Fire Marshal Division

Re: G & D Hauling
219 Jarco Drive
Fuquay Varina, NC 27526

Application Number BCOM1904-0002

Thank you for submitting the plans for the tank installation. The plans have been carefully reviewed by a qualified code enforcement official to examine for compliance with the North Carolina Fire Prevention Code and all other fire protection regulatory documents. There are some items that were found during the plan review process that need to be addressed before a final inspection of the new facility can be given. These items are outlined and described below.

PROPOSED SITE AND UTILITY PLAN

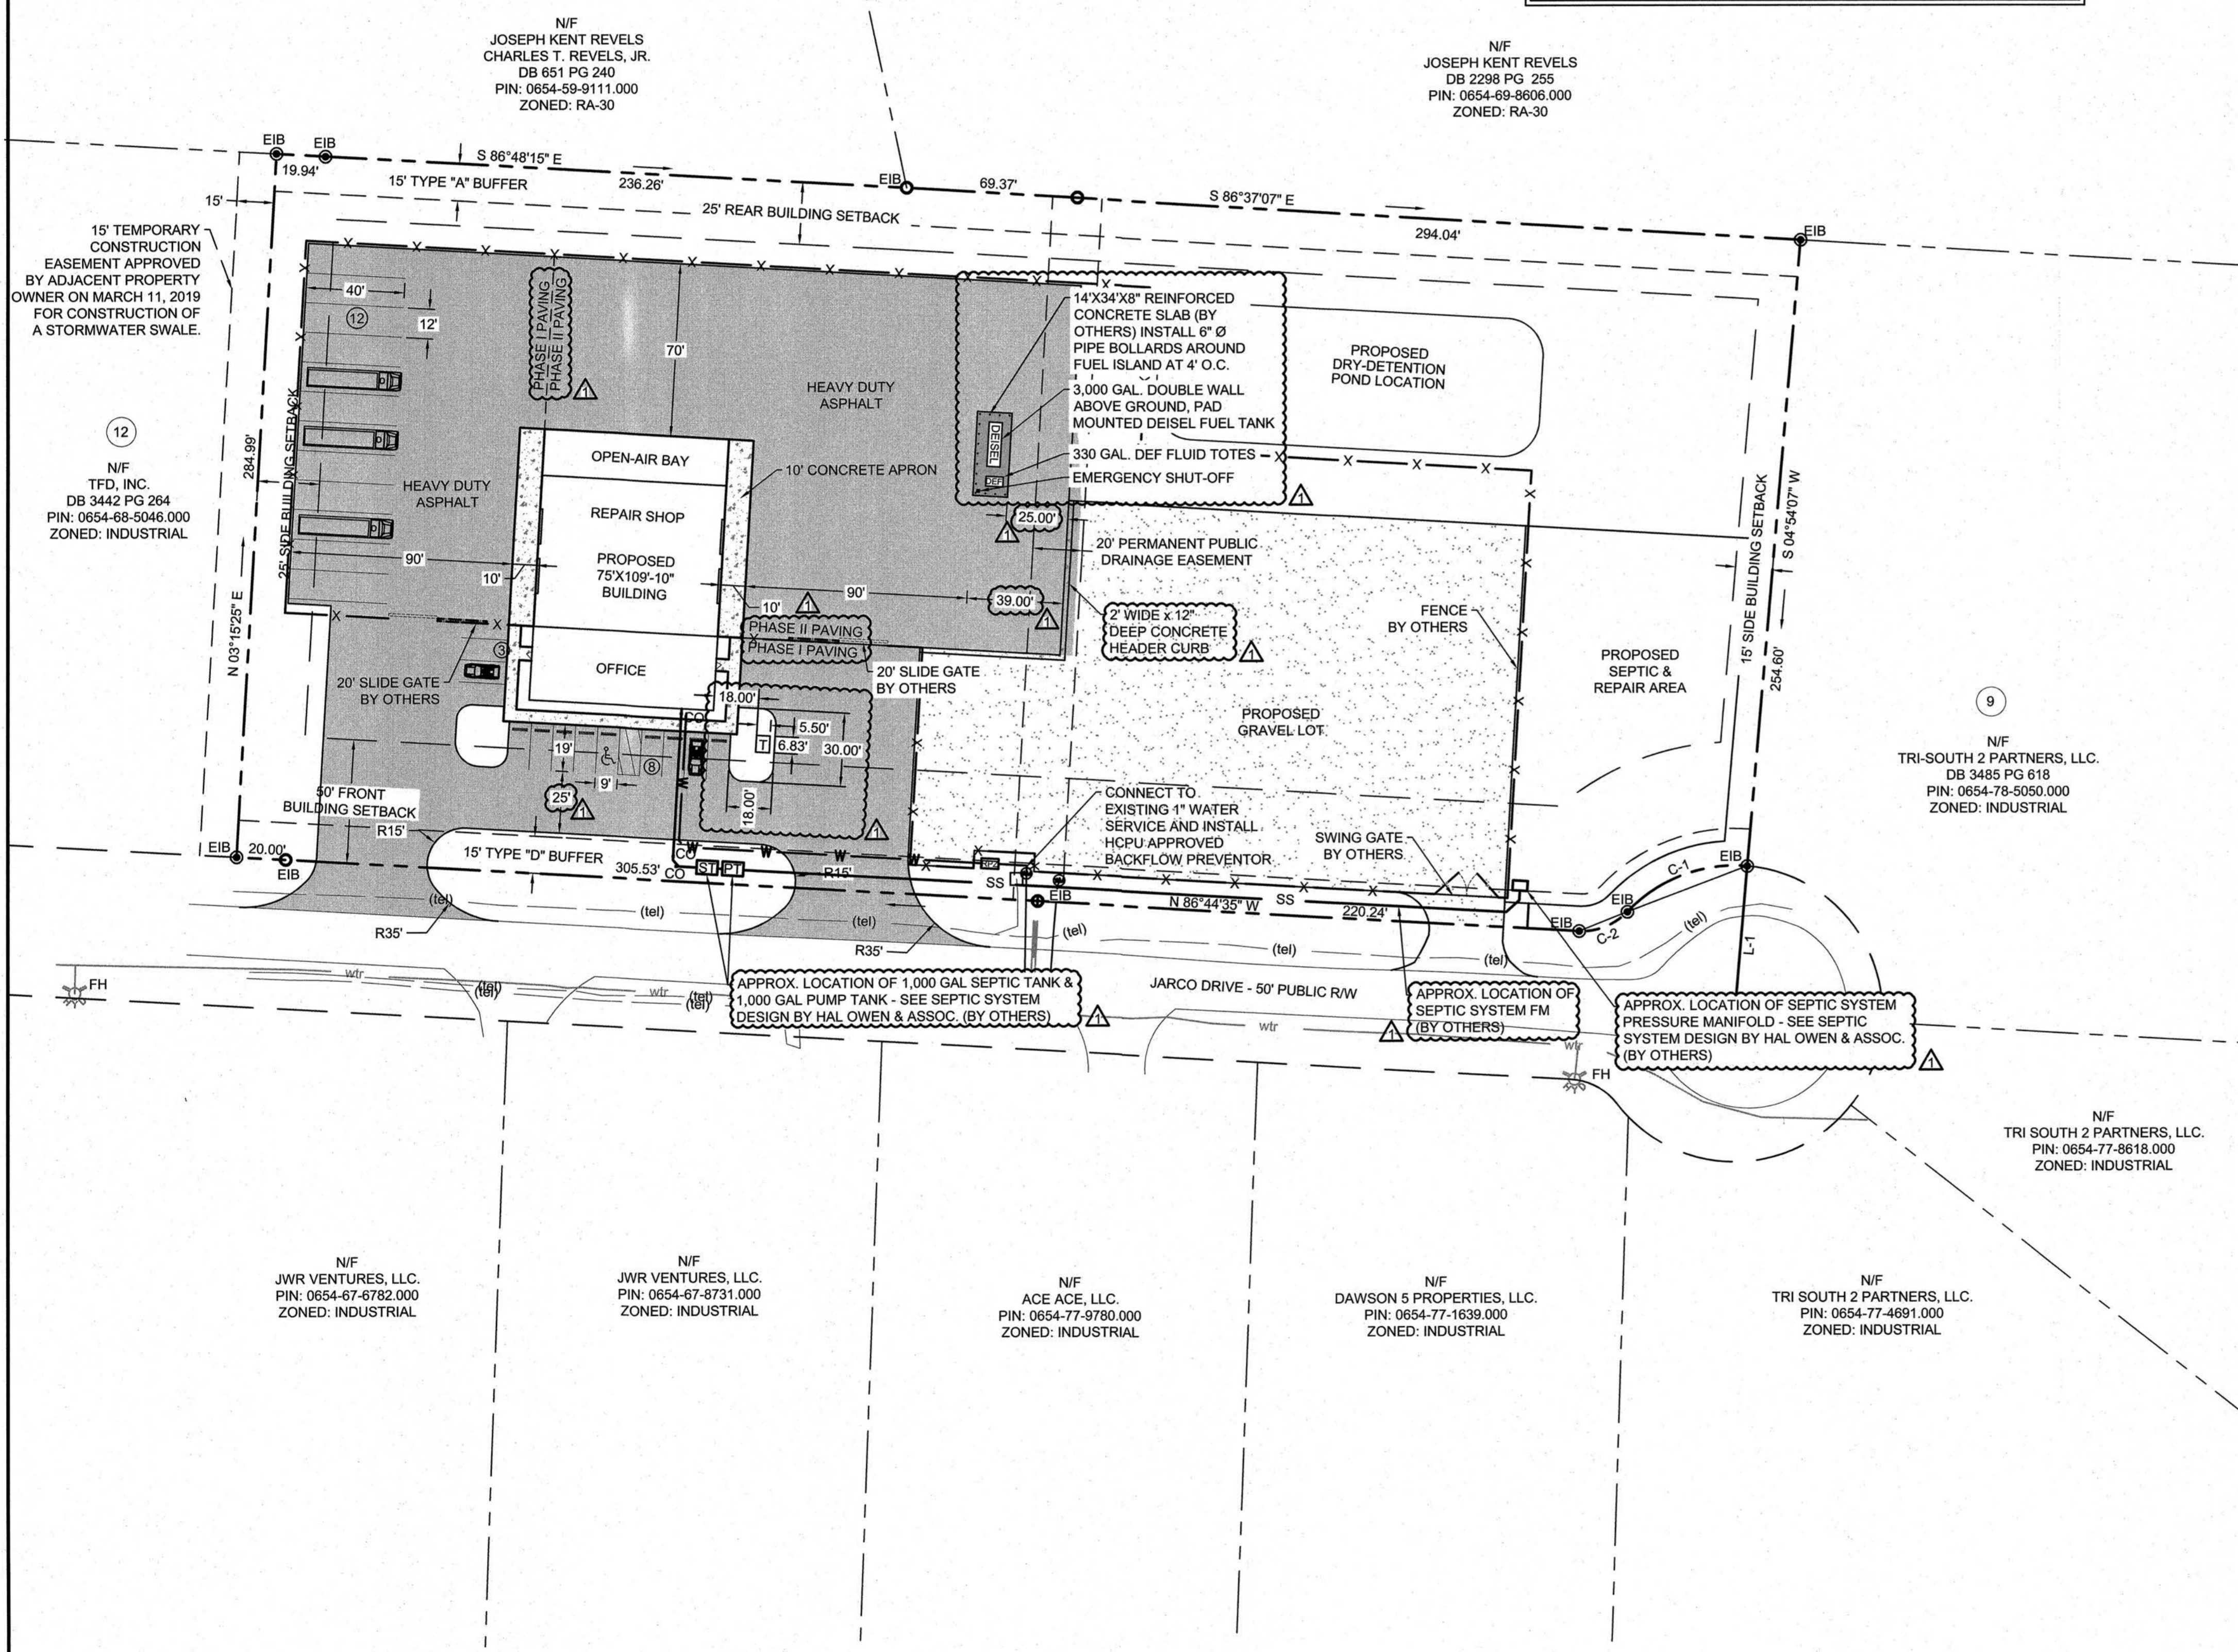
- **3404.2.9.6.5 Vehicle Impact Protection**
 - Where any portions of the fuel storage or dispensing components are subject to vehicular impact, they shall be protected therefrom, either by having the impact protection incorporated into the system design in compliance with the impact test protocol of UL 2085, or by meeting the provisions of Section 312 NCFC, or where necessary, a combination of both. Where guard posts or other approved barriers are provided.

- **Testing of Dispensers**
 - After initial pipe testing and setting of dispensers, the dispensers will be examined and tested.
 - The emergency fuel shut off switch will be tested.
 - They shall be independent of each above-ground tank.

Tanks to be Installed (1 tank total):

3000 Gallon Diesel
